Our Ref: 20048269
PINS Ref: EN010119
Date: 24 June 2025
Telephone: 03330 322546

Planning Act 2008 – Application by North Falls Offshore Wind Farm Limited for an Order Granting Development Consent for the North Falls Offshore Windfarm (EN010119)

REP5-035 - Document Indicative Planting Cross-sections at the Onshore Substation (Rev 2)

Document Reference:	9.30
Volume:	9
Date:	May 2025
Revision:	2

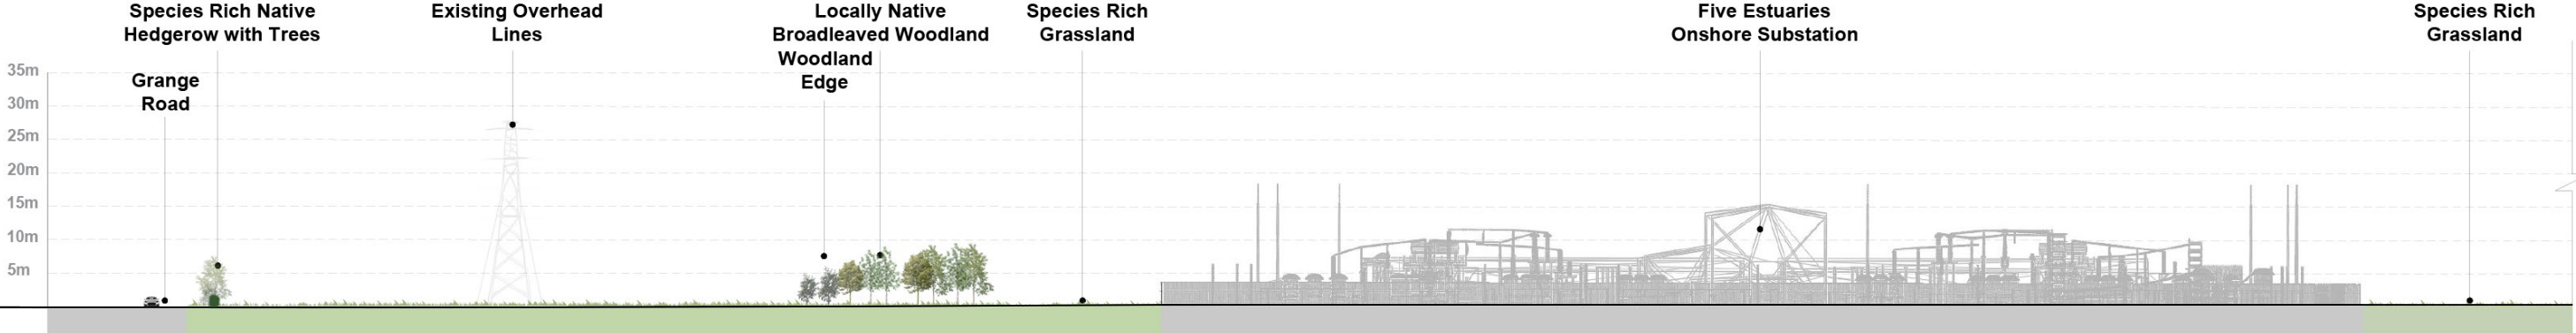
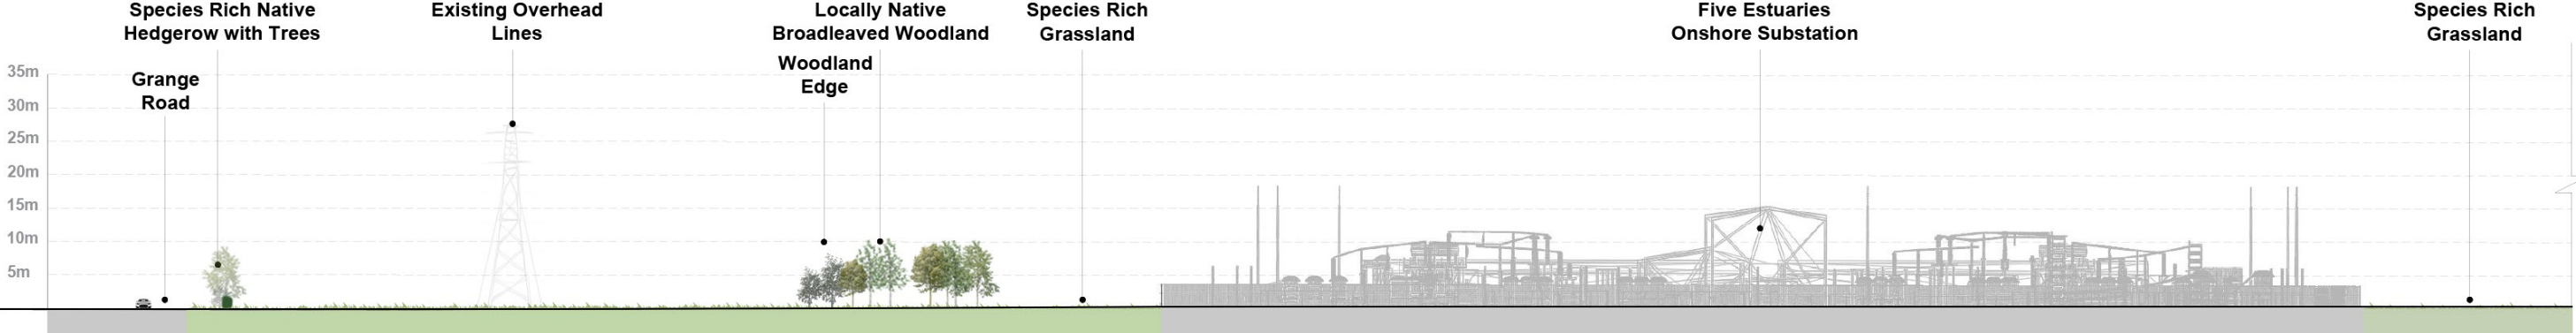
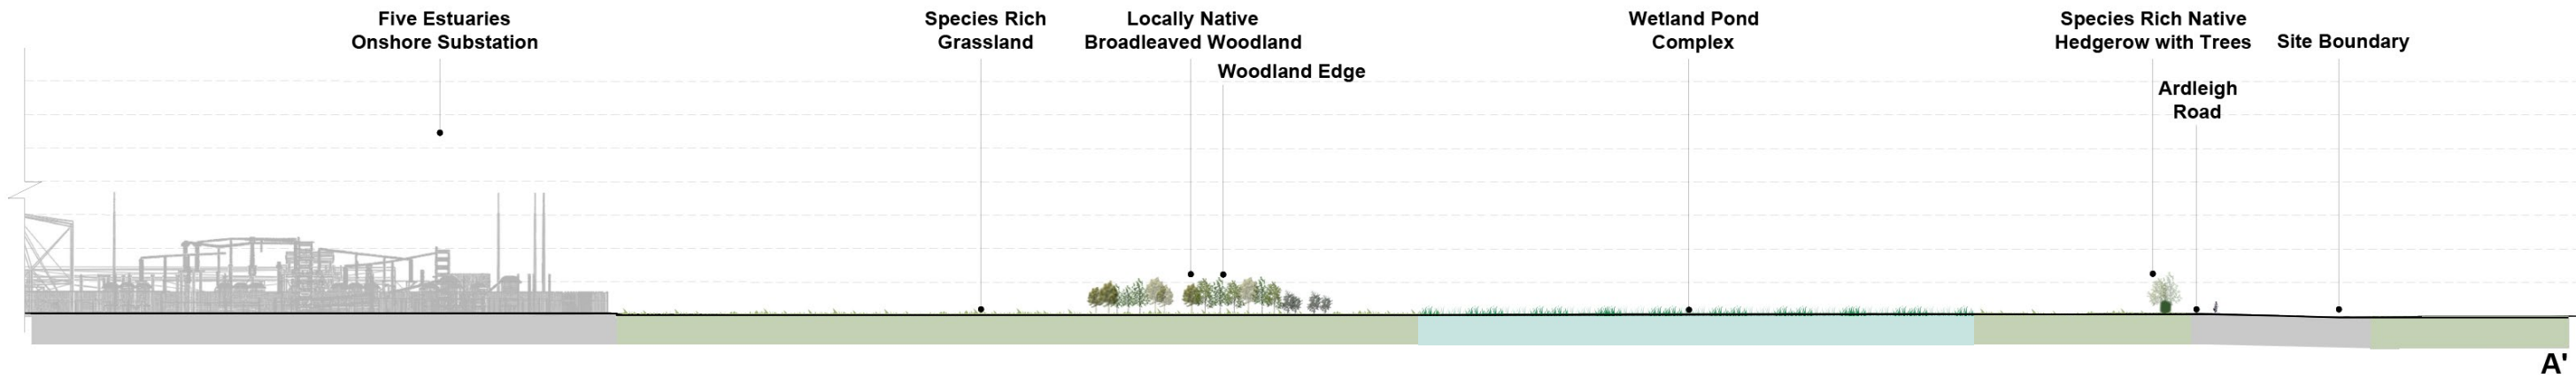
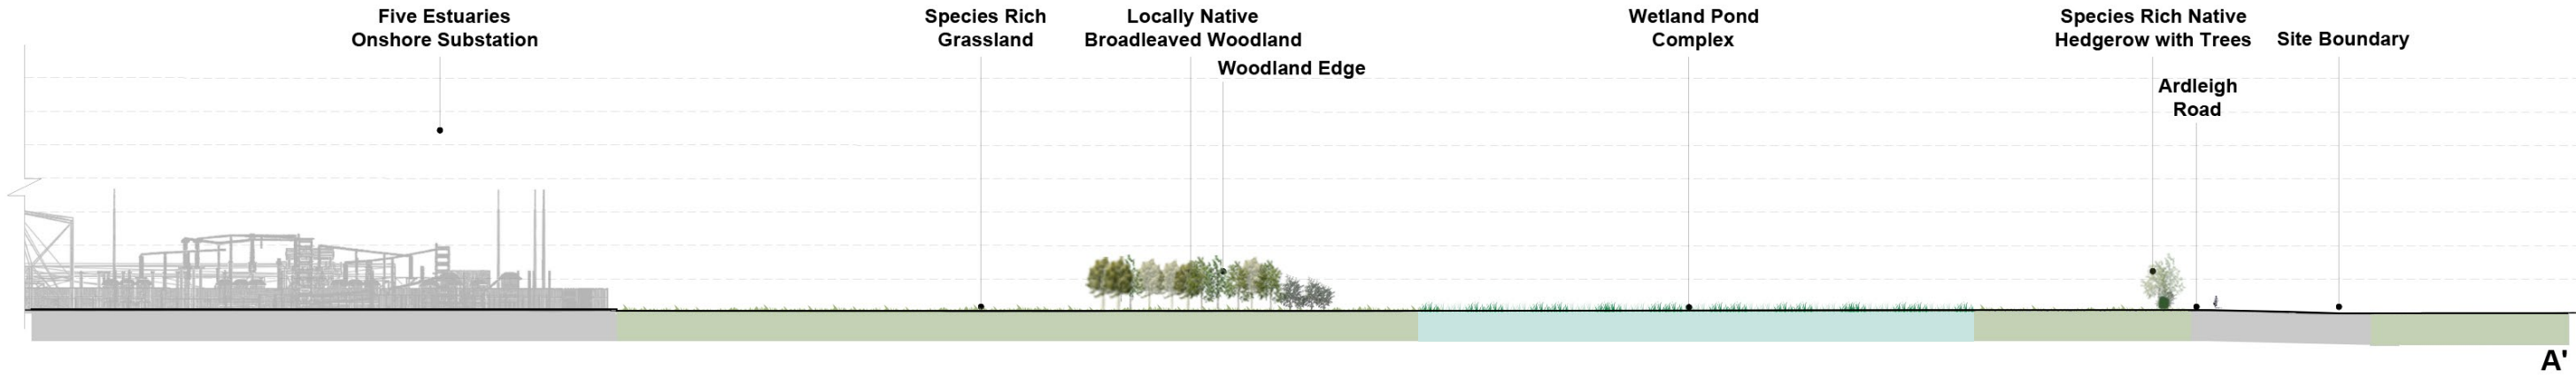
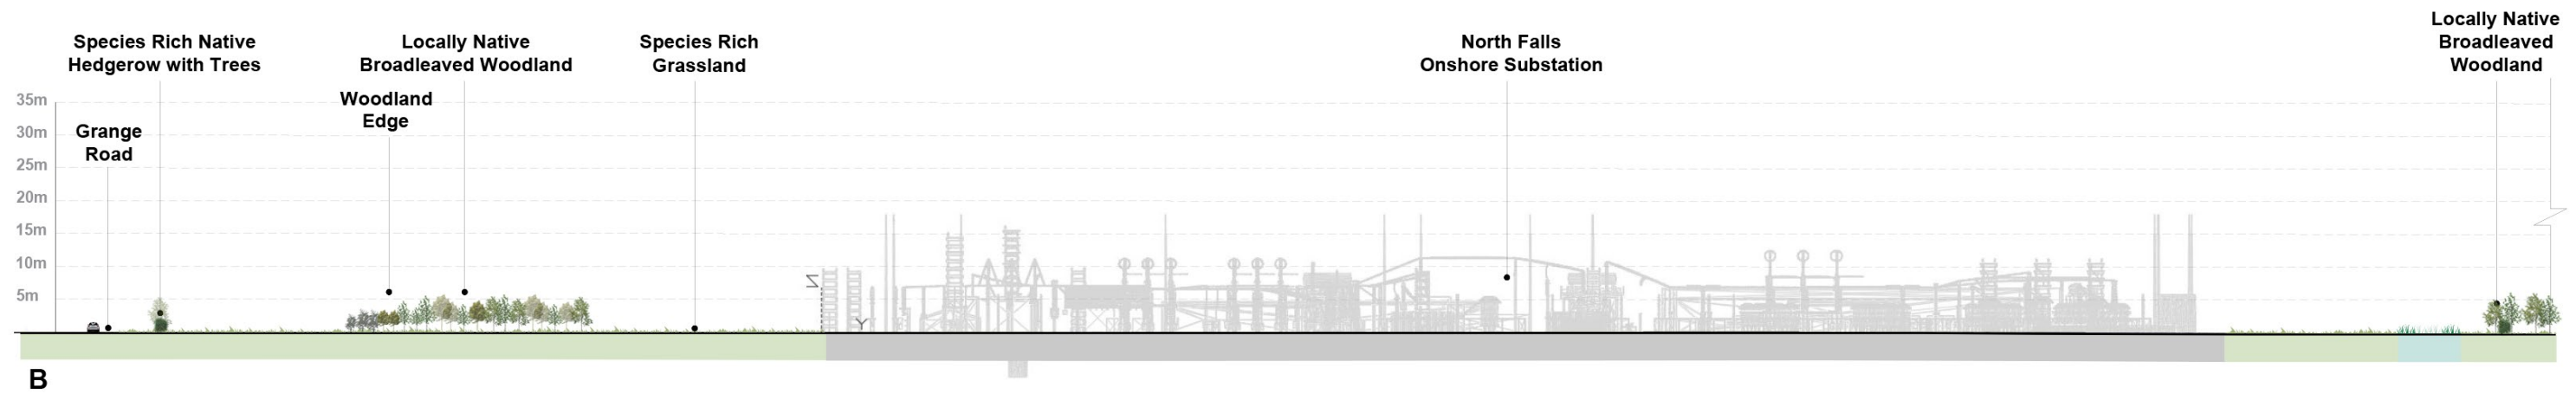
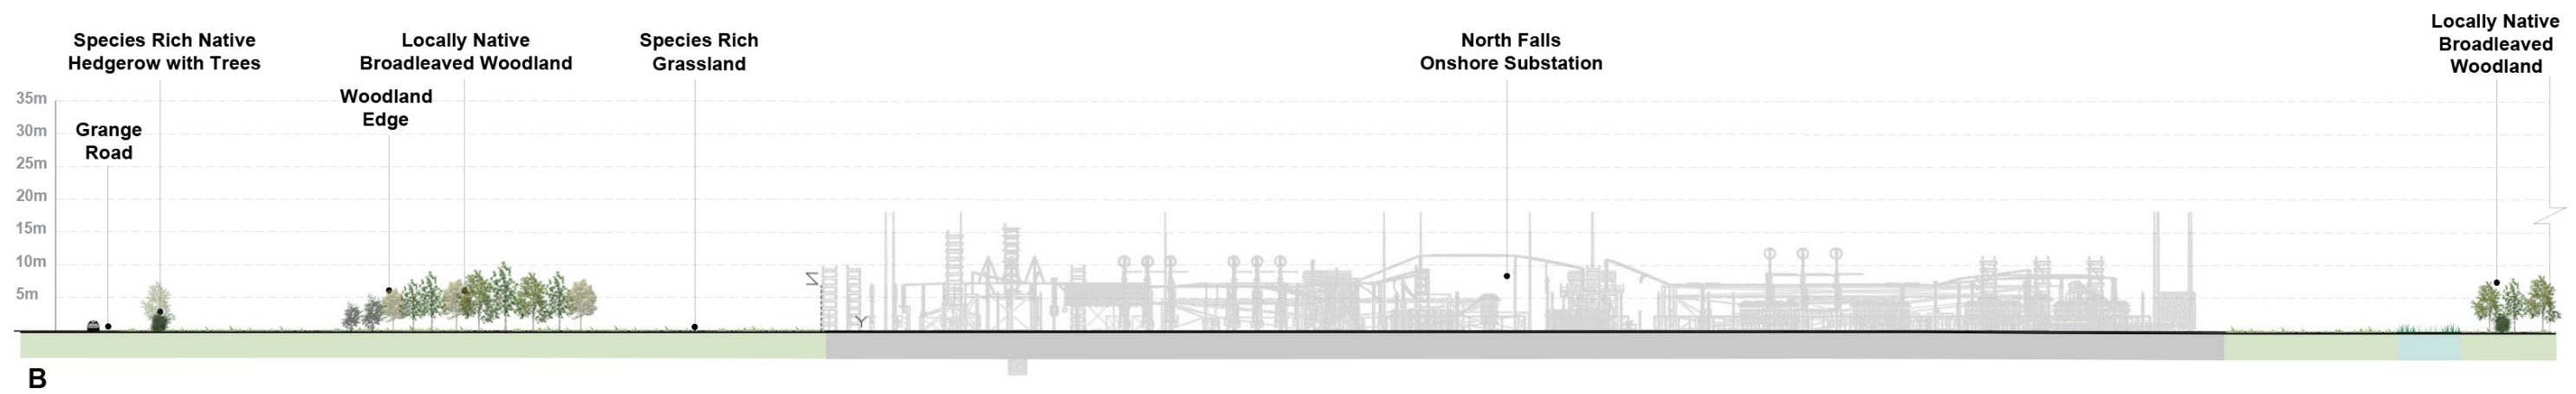
- 3.4. We welcome the revised cross-sections. Our position remains that the proposed infrastructure would have a major significant visual impact on close-to receptors for a

minimum of ten years with several of the taller elements giving rise to residual moderate impacts creating the perception of an industrialised landscape.
